Mr Mark DeSylva
Schools Development Manager
Catholic Education Office Diocese of Parramatta
12 Victoria Road
PARRAMATTA NSW 2150
04/06/2021

Westmead Catholic Community Education Campus (SSD-10383)
Clarification of open space details

Aditi Coomar
Team Leader, School Infrastructure Assessments

DRAWING TITLE
PRIMARY SCHOOL LANDSCAPE PLAN - GROUND LEVEL

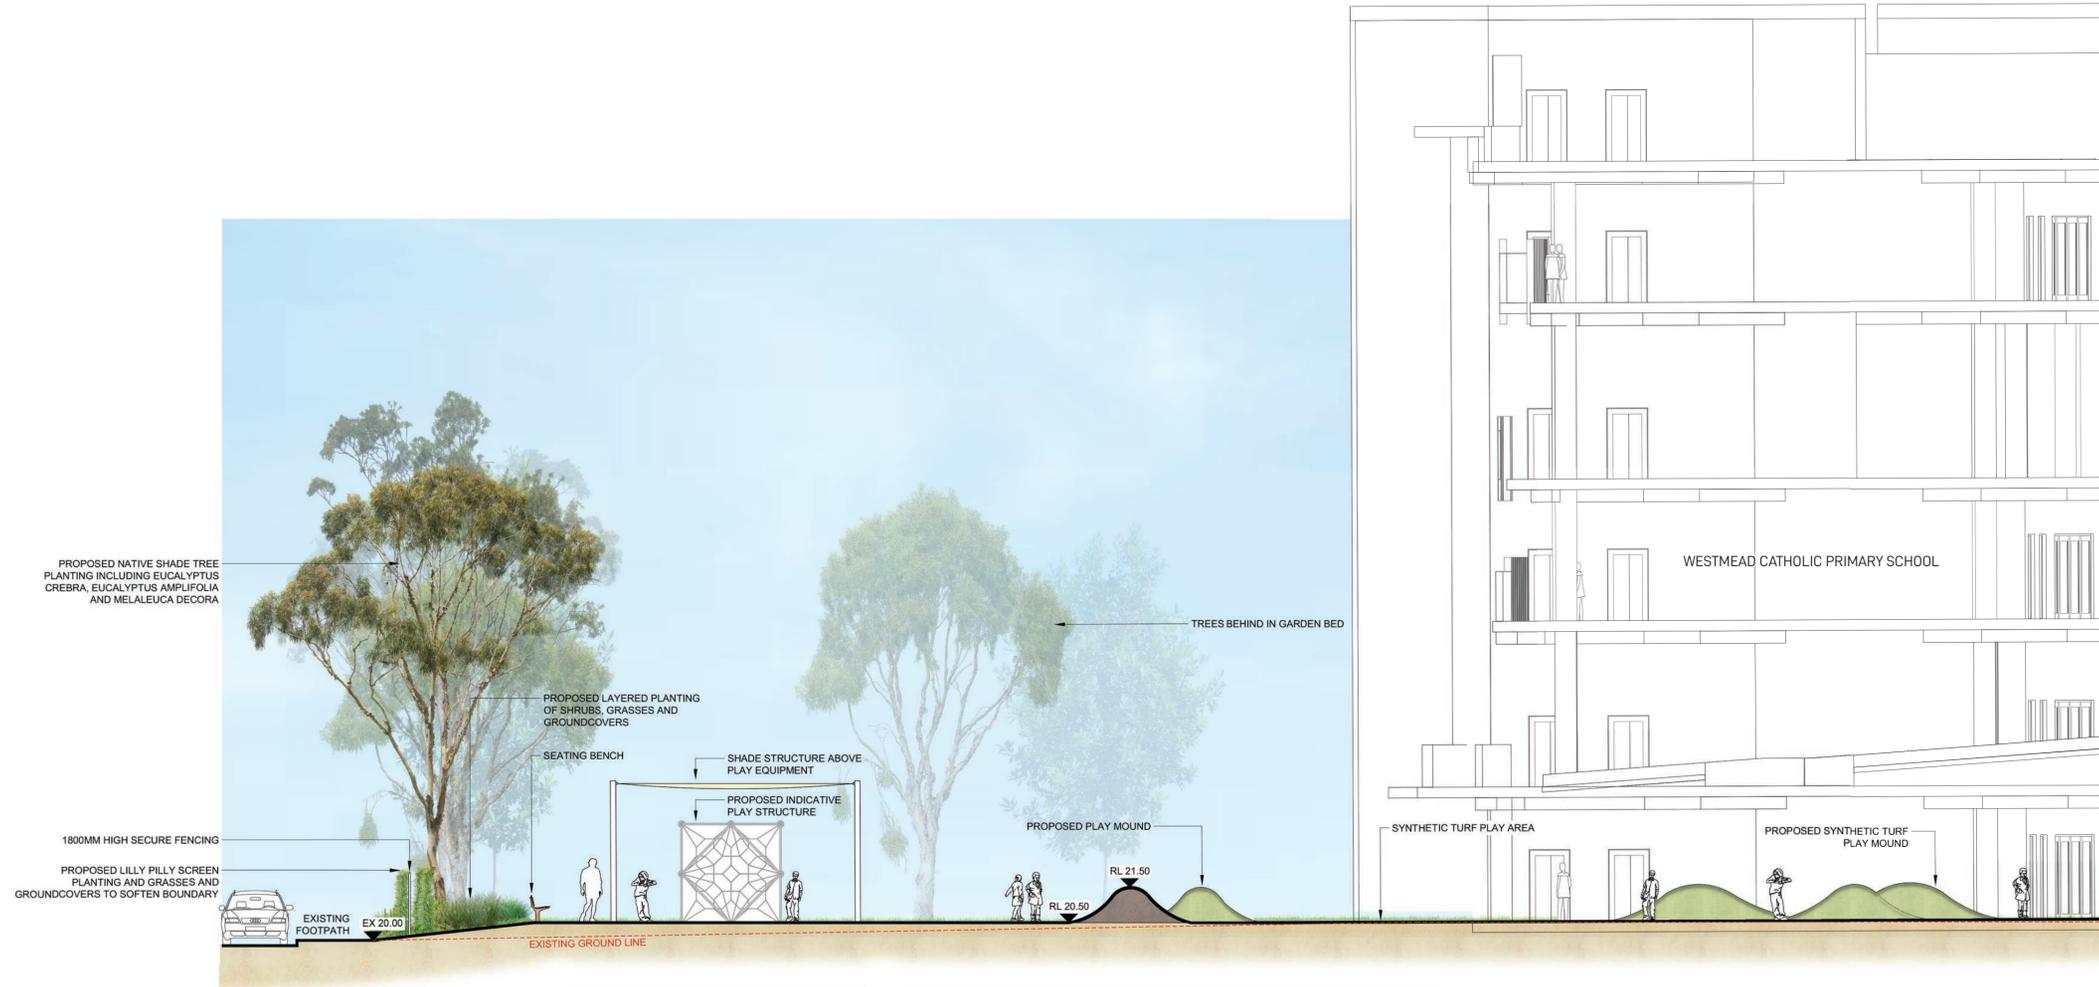
- c) Justify the inclusion of the circulation/access areas to the east and north of the primary school building within the open space calculations (area highlighted in blue below). The Department notes that this area includes circulation routes and bicycle racks and does not appear as functional play space.
